Your Ref: OWPC18835
Our Ref: FP/106/18/HH
Please ask for:
Mr Z Denton

14th June 2018

Two storey rear extension & new front dormer roof window.
29 Roundle Avenue Felpham

PROPOSED FIRST FLOOR PLAN 1:100

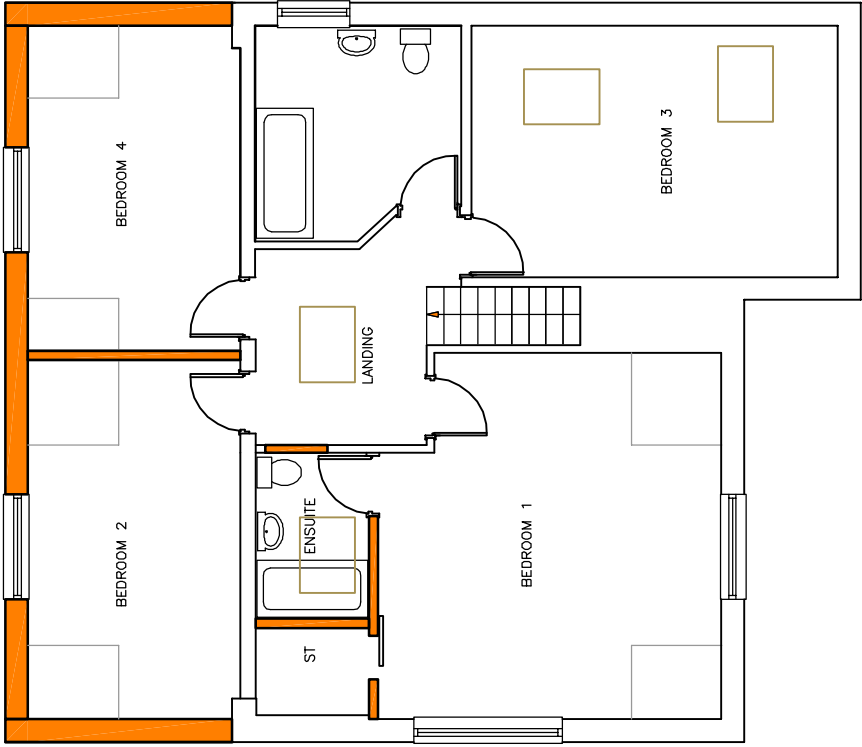
No Objection - providing obscure glass is put in bathroom windows.
